SUBJECT: EG/6/18/RES - Approval of reserved matters following outline consent
EG/71/14/OUT for the erection of 60 No. dwellings with new vehicular access, open space &
ancillary works.

**Eastergate Fruit Farm, Barnham Road, Barnham, Eastergate, West Sussex,
PO20 3RP**

RECOMMENDATION:

Plots 28-31

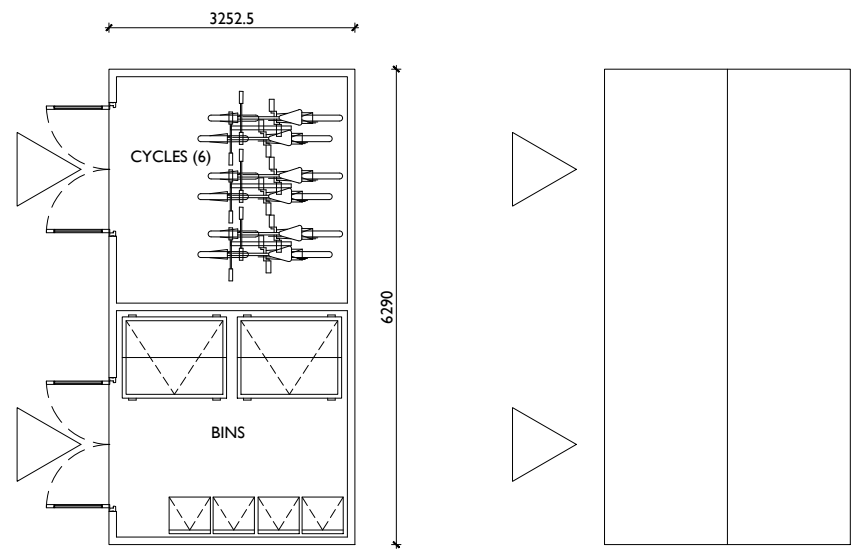
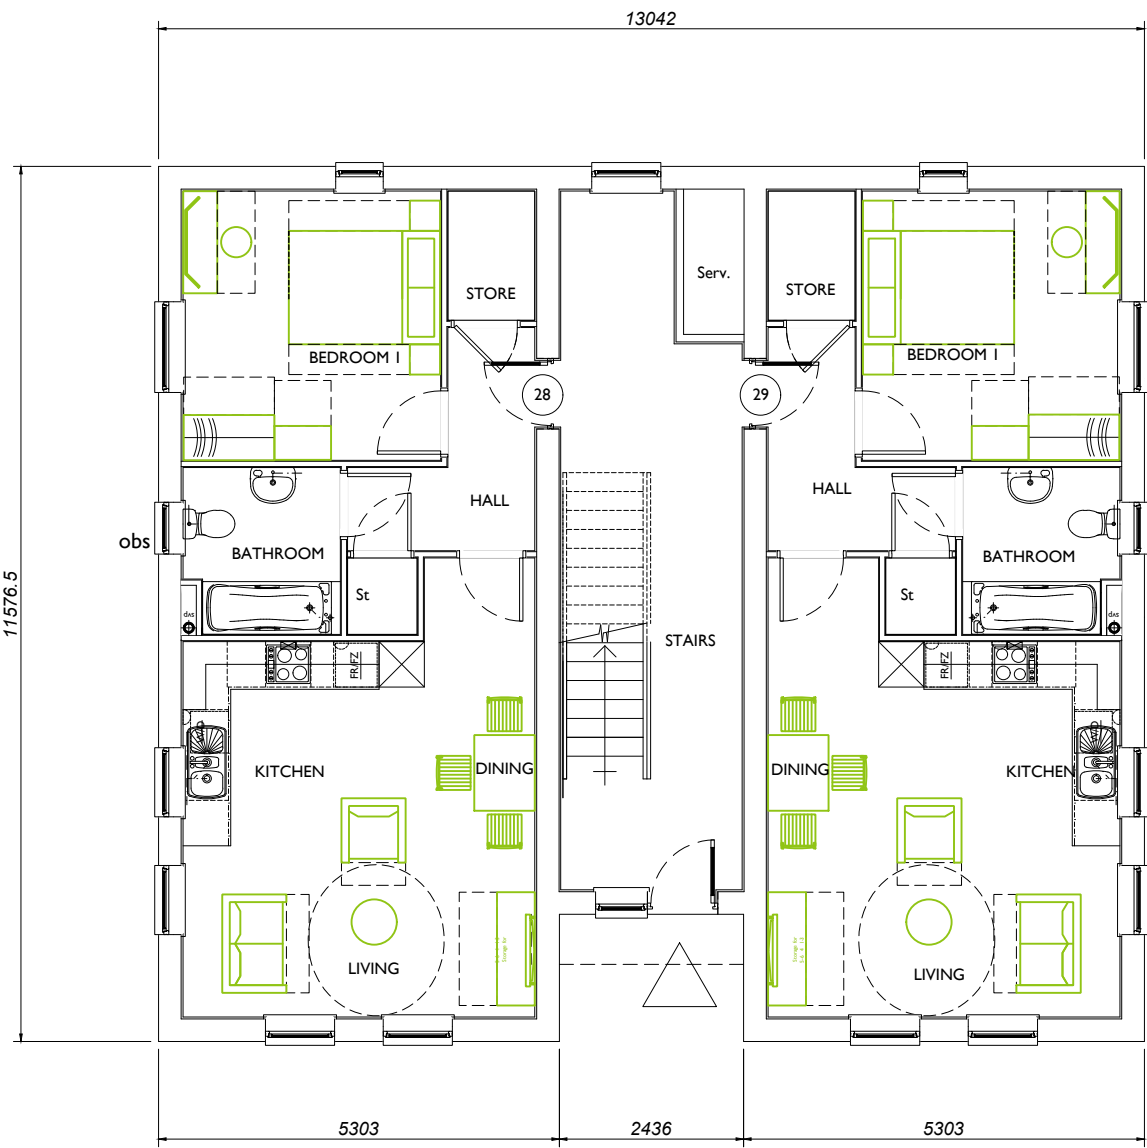
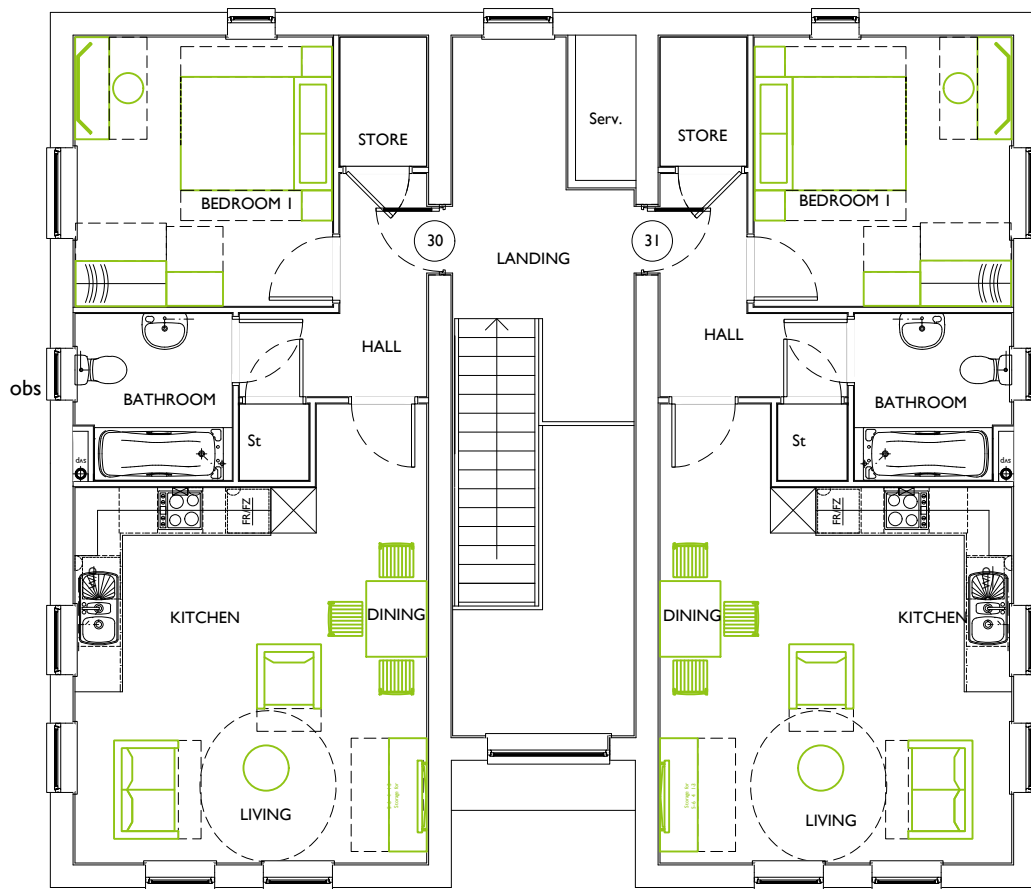
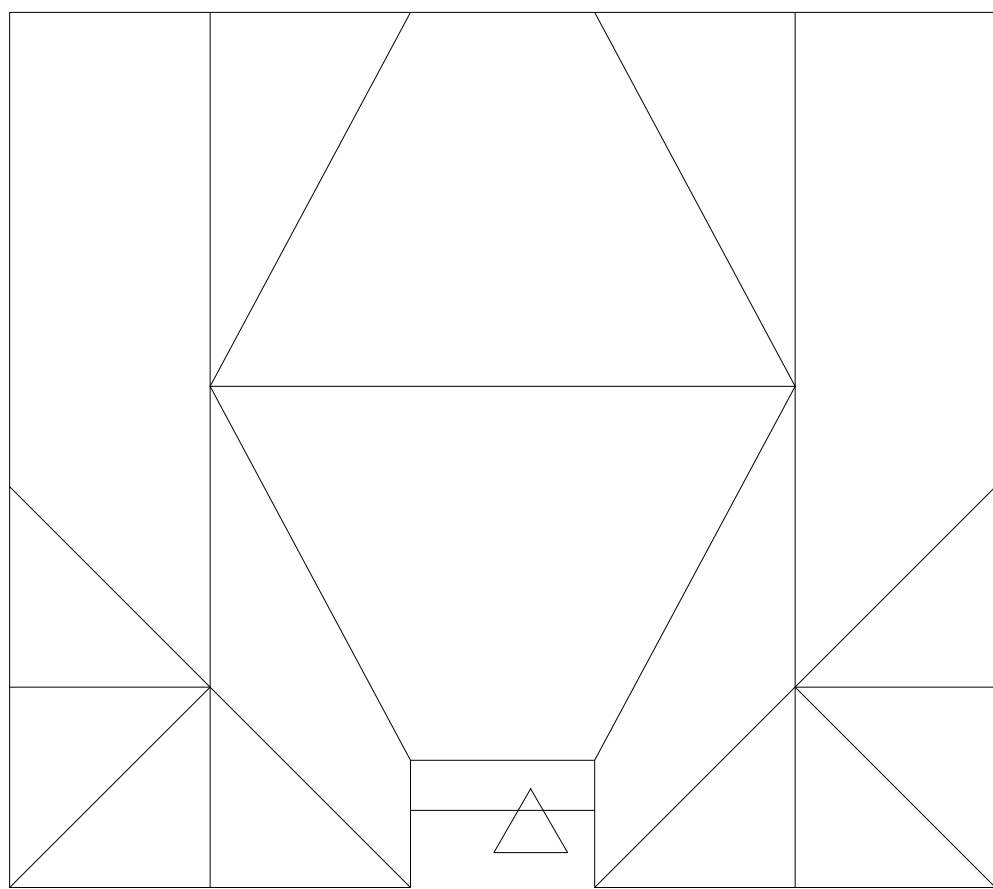
13. The parallel visitor parking bays to the rear of plots 28-31 would be quite difficult to access and exit due to the limited turning space within the parking court. Compared with other parts of the development, there are relatively few visitor parking bays on-street in the vicinity of these plots. There would seem scope for these two bays to be moved onto the access road alongside plot 7. The visitor bays would then be much more apparent rather than being included within a private parking court.

DRAWING TITLE
Plot 60
House Type 404C
Floor Plans & Elevations

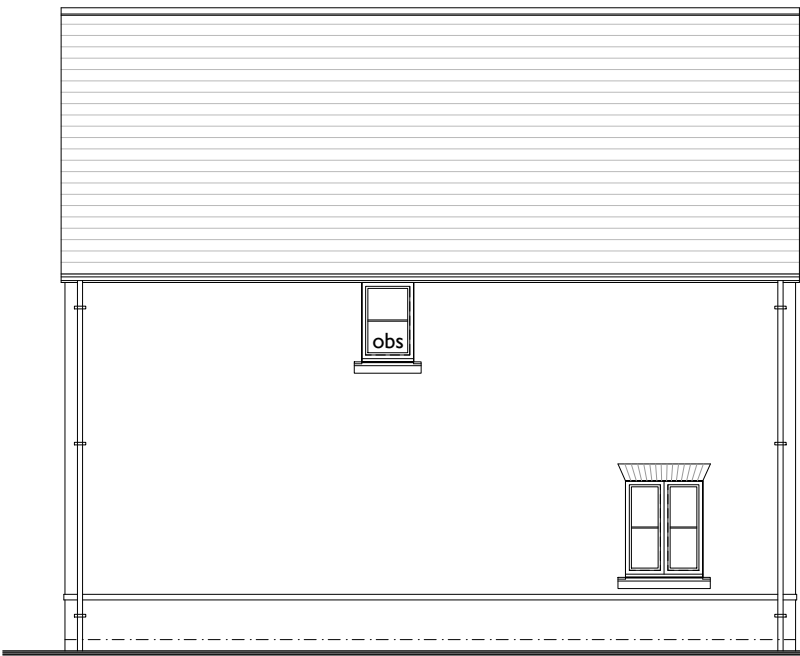
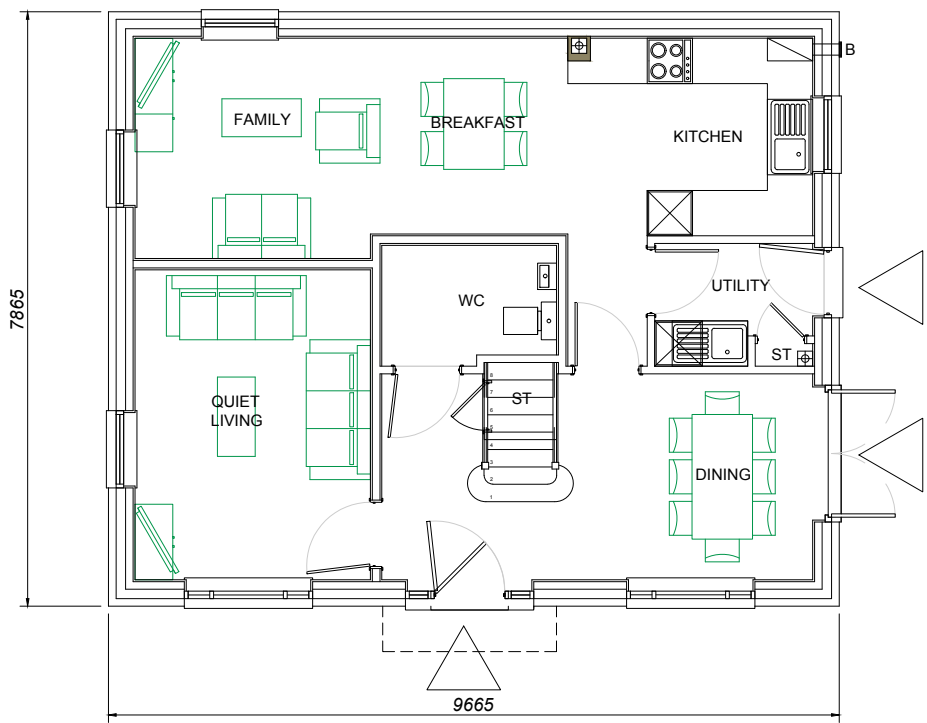
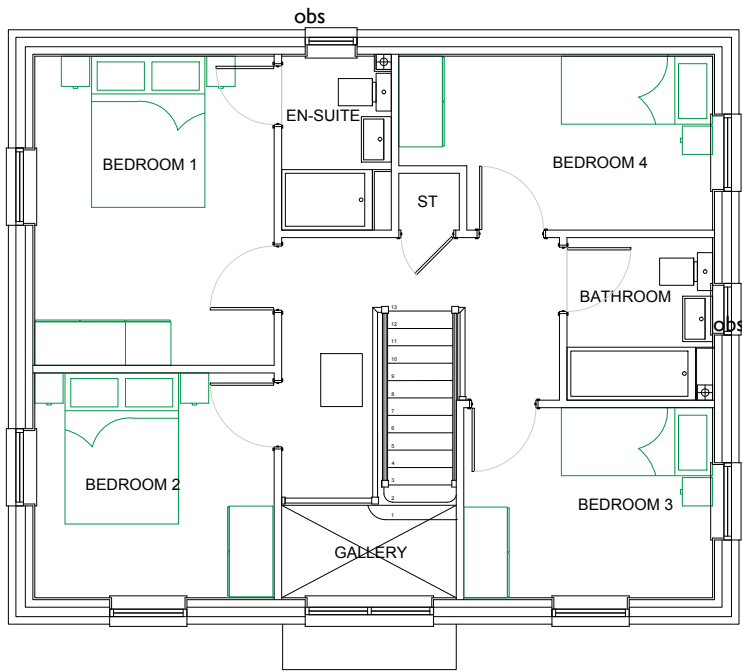
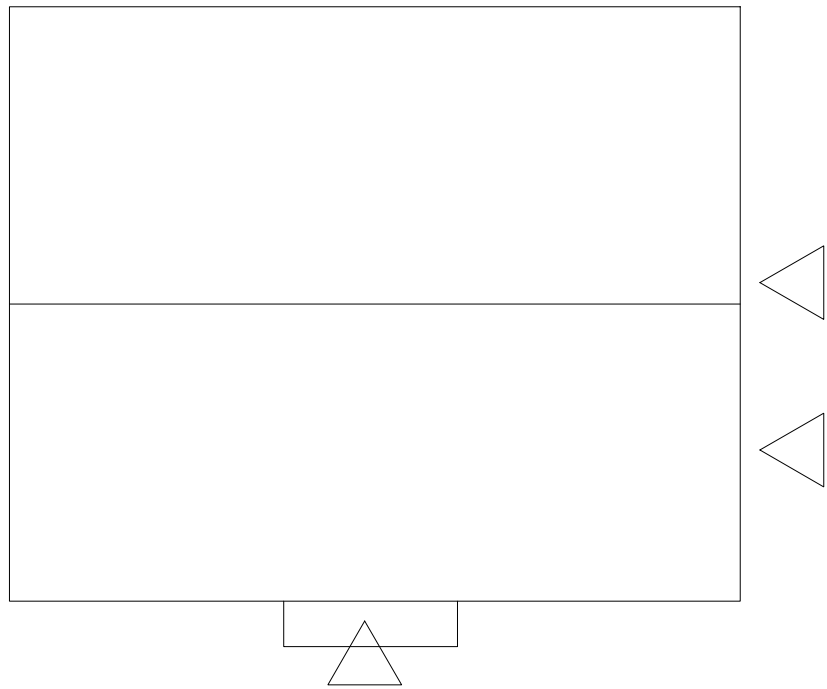
15. Whilst not a safety consideration, it's unclear why plots 51 and 60 have such large driveways. These could seemingly be reduced in length without any apparent issue.
